From: Simon Davis
Sent: 01 February 2022 16:41
To: Planning Scanning
Subject: FW: Drove Lane, Yapton - Surface Water Drainage Y/185/21/DOC

Engineers Comments Regarding Condition 9

Engineers Comments Regarding Condition 10

ELEVATION OF HEADWALL
OUTLET FROM END OF DITCH

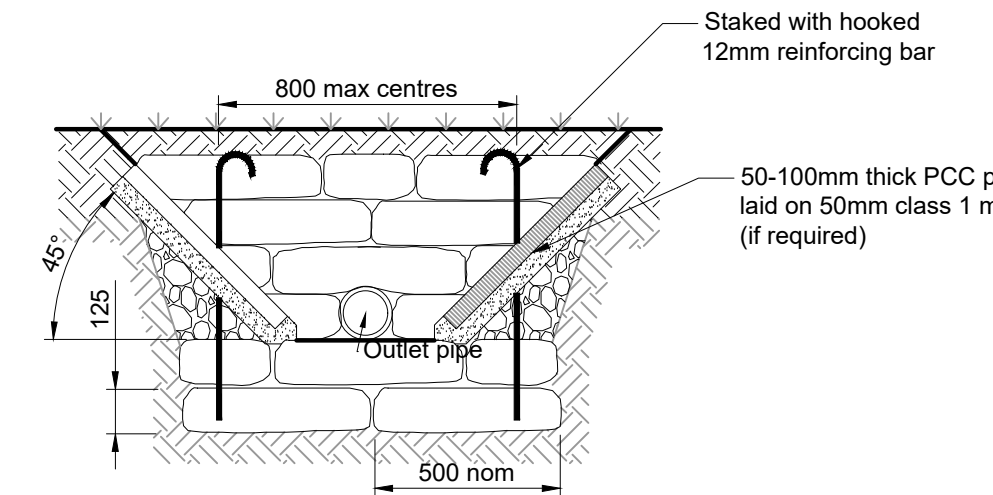
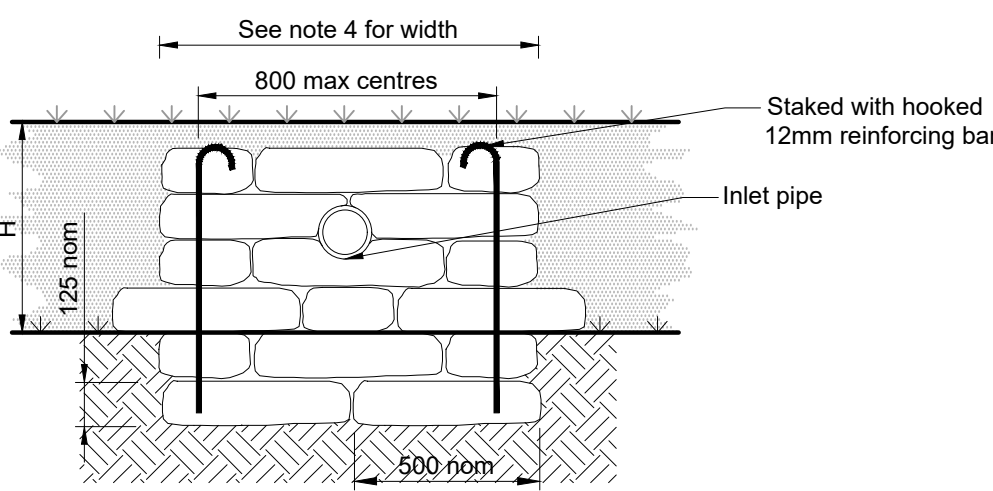
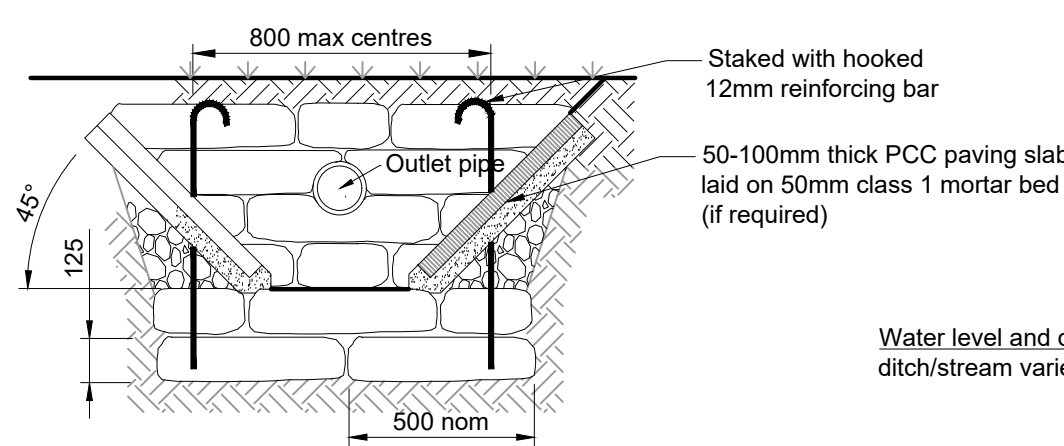
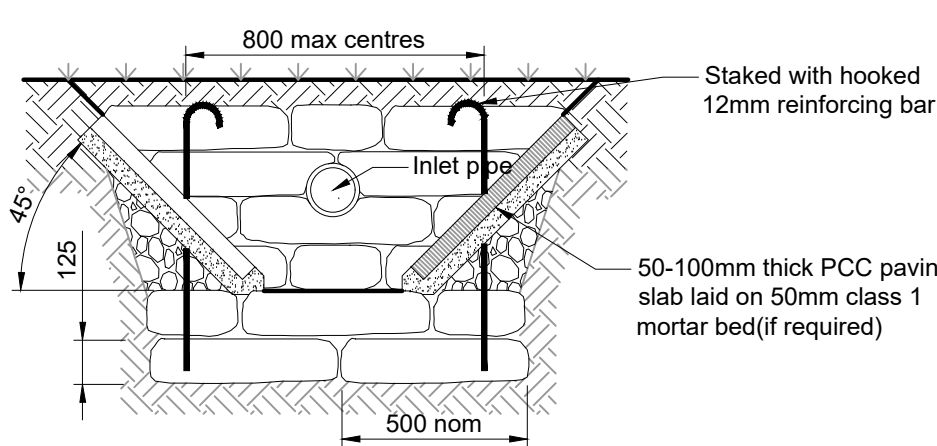
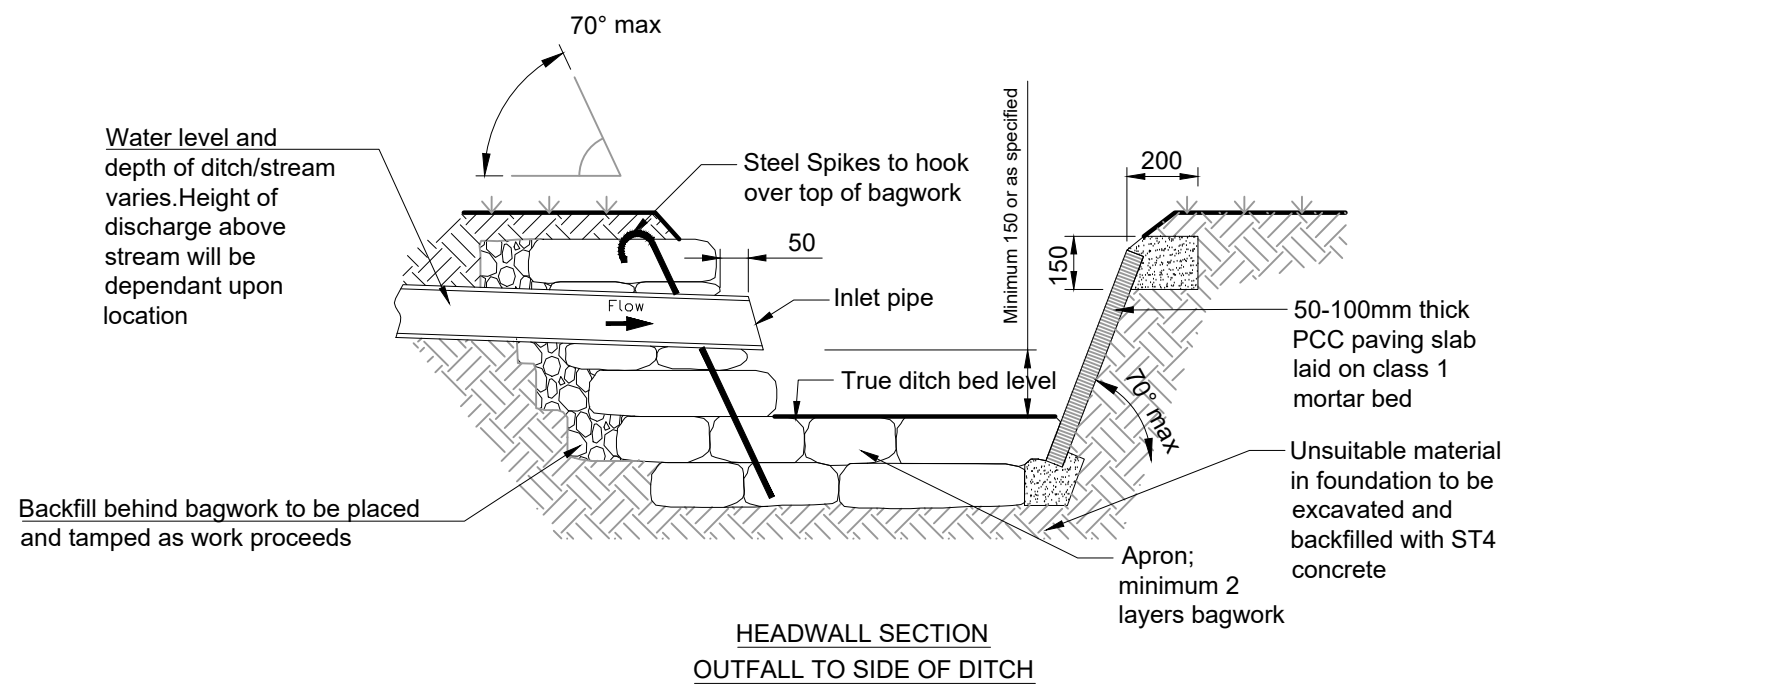
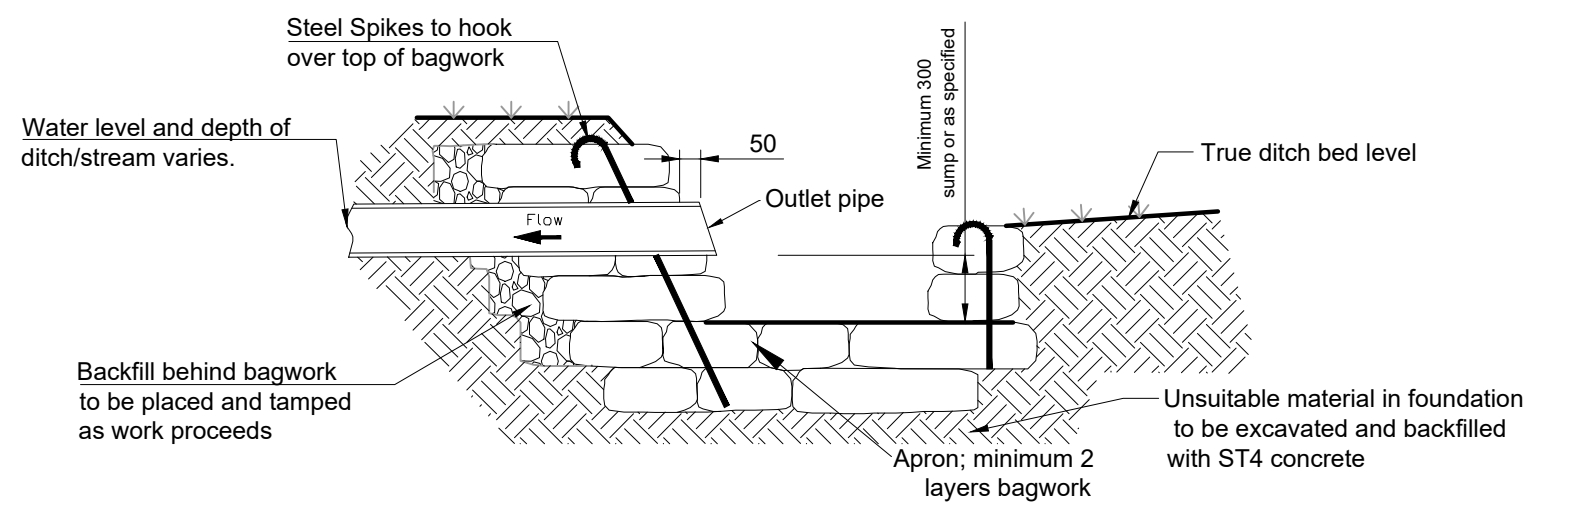
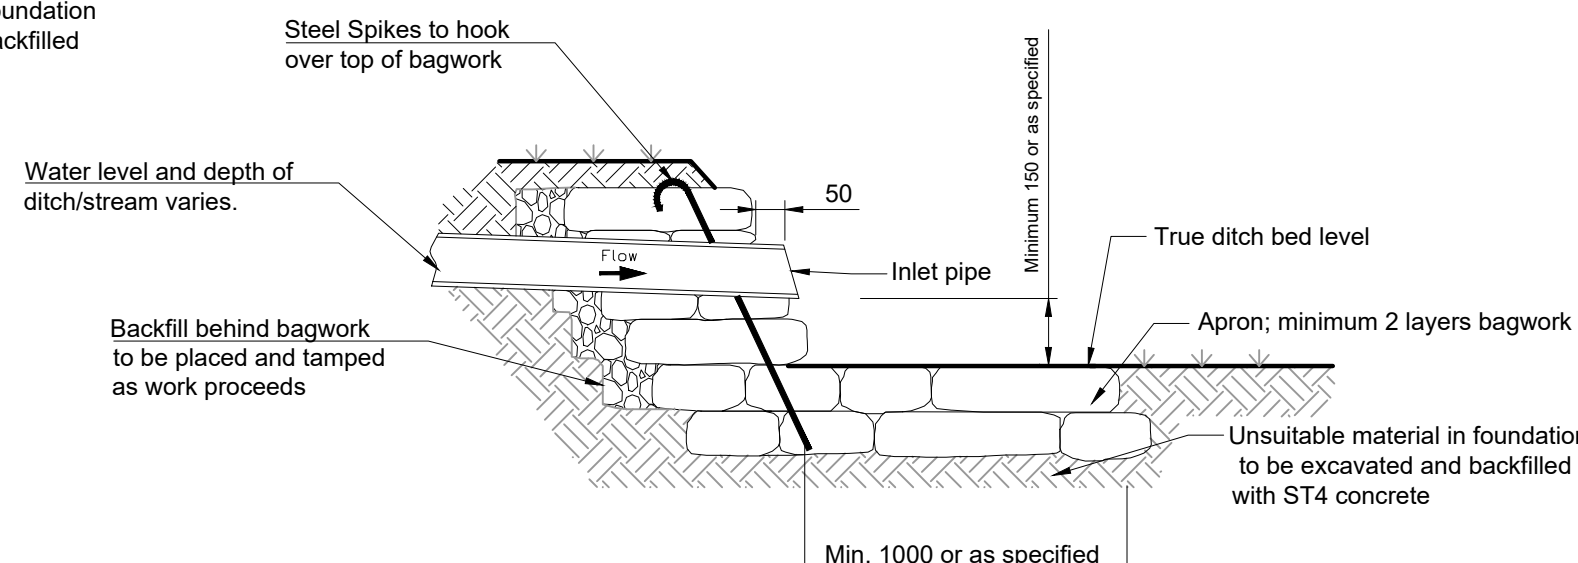
A site specific construction detail drawing of the outfall from the system to the watercourse should be provided. This should be consistent with the land drainage consent detail.

TYPICAL TREE
PIT IN POS
CLOSE TO
ATTENUATION
FEATURE
SCALE 1:20

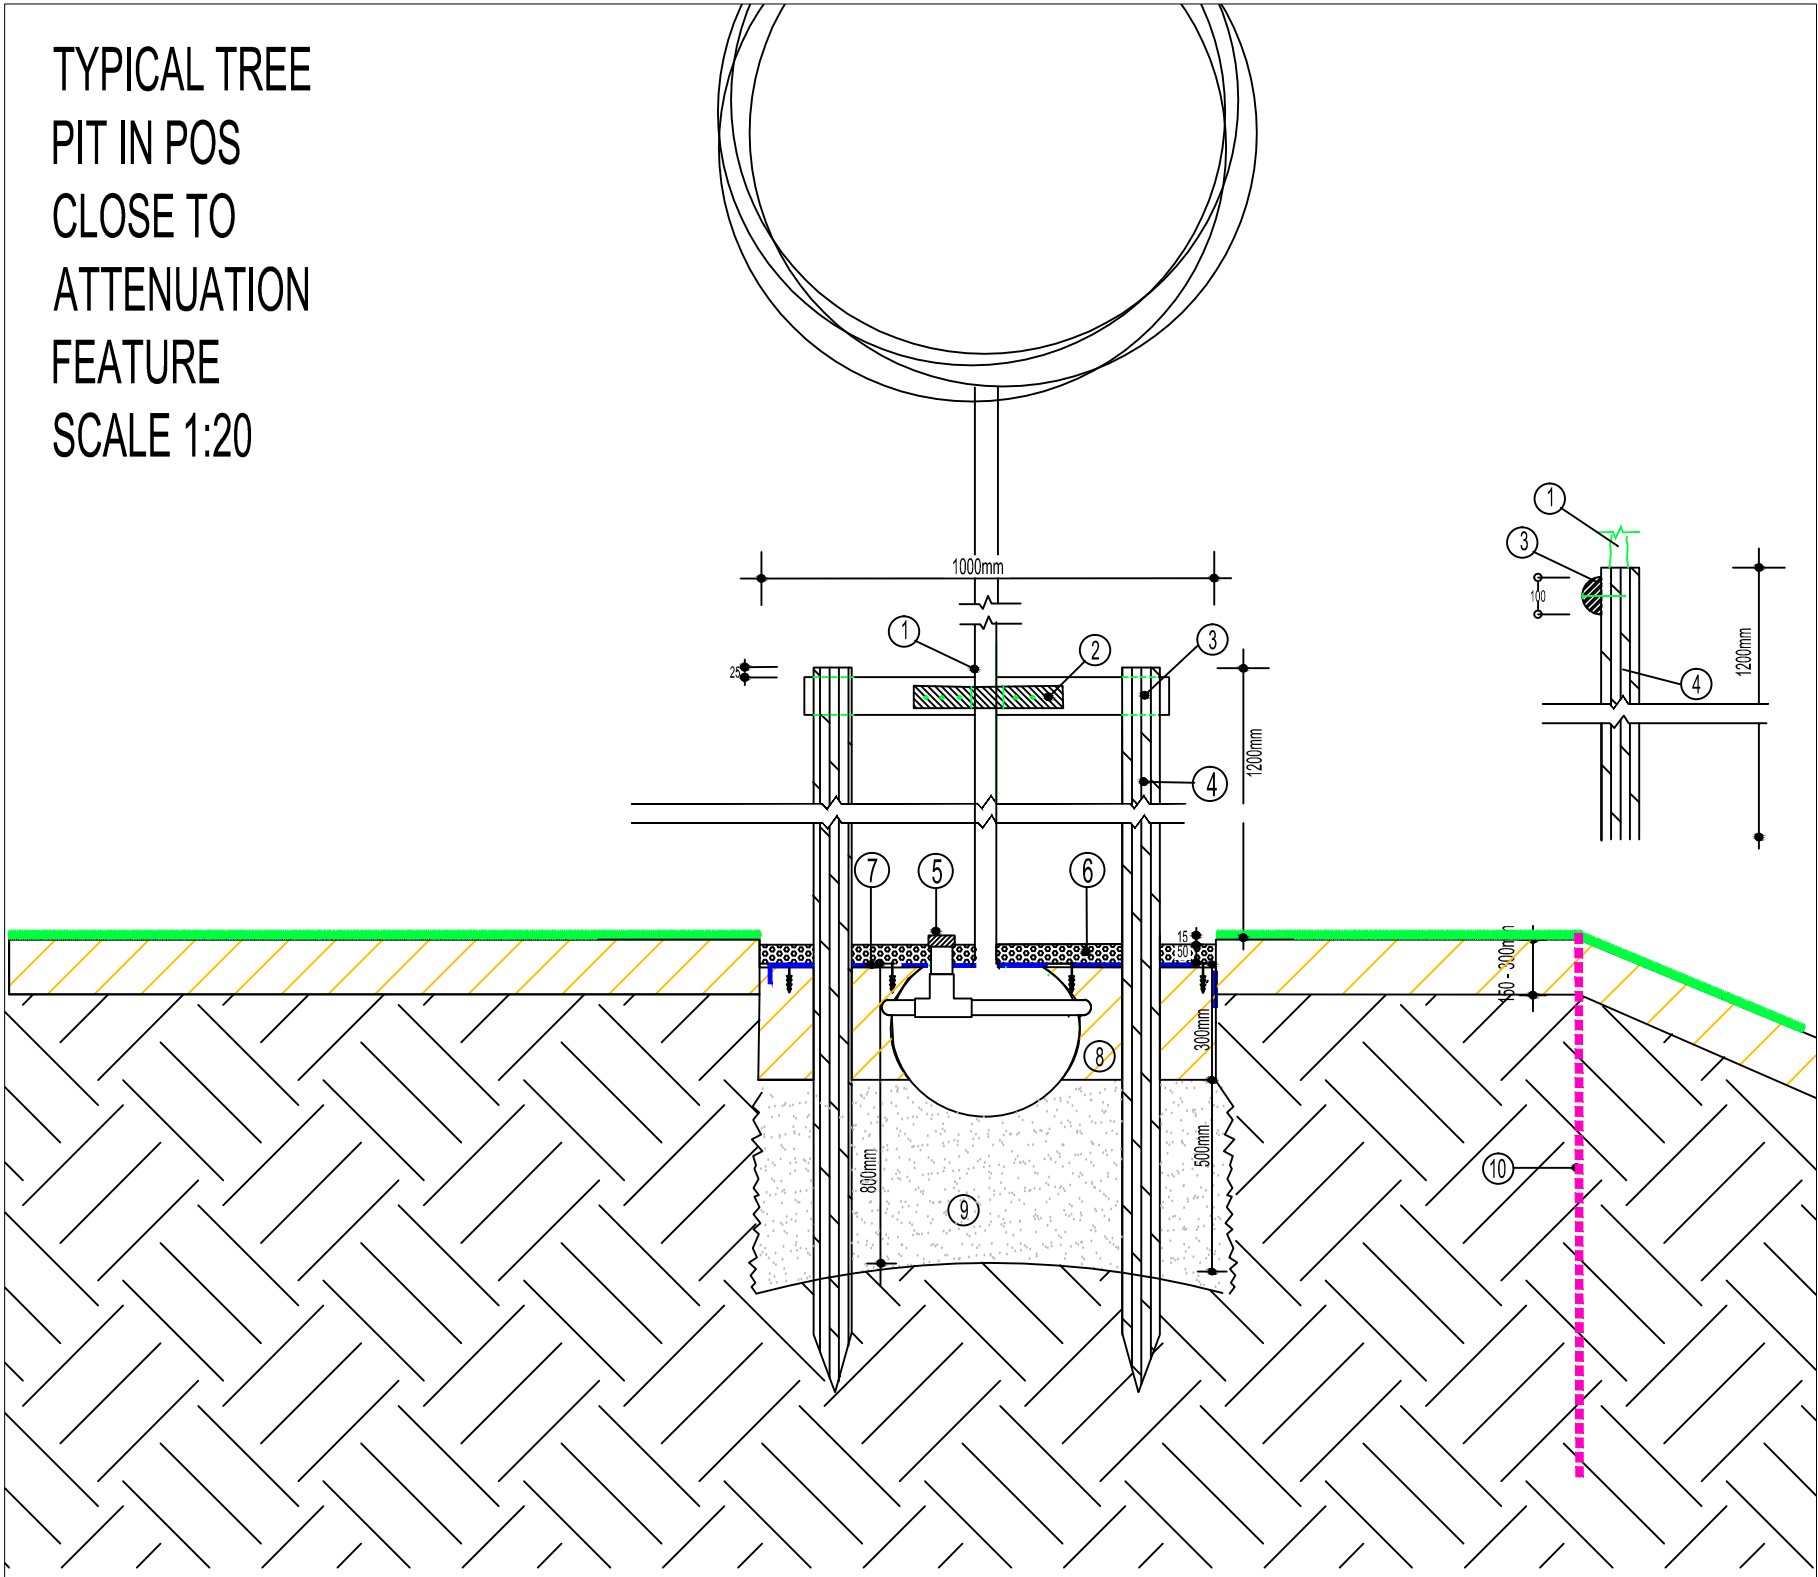
There is significant conflict between soft landscaping proposals and drainage proposals. A significant number of trees are proposed in very close proximity to lined surface water drainage features. Root potential areas should not overlap with SuDS features. We note that some root barriers are proposed, however we do not generally support these. Furthermore, the extent of the barriers proposed would not adequately protect the drainage features.

Please can plans showing root potential areas of trees be provided, with drainage features shown. Once this is provided the tree officer should also be consulted.
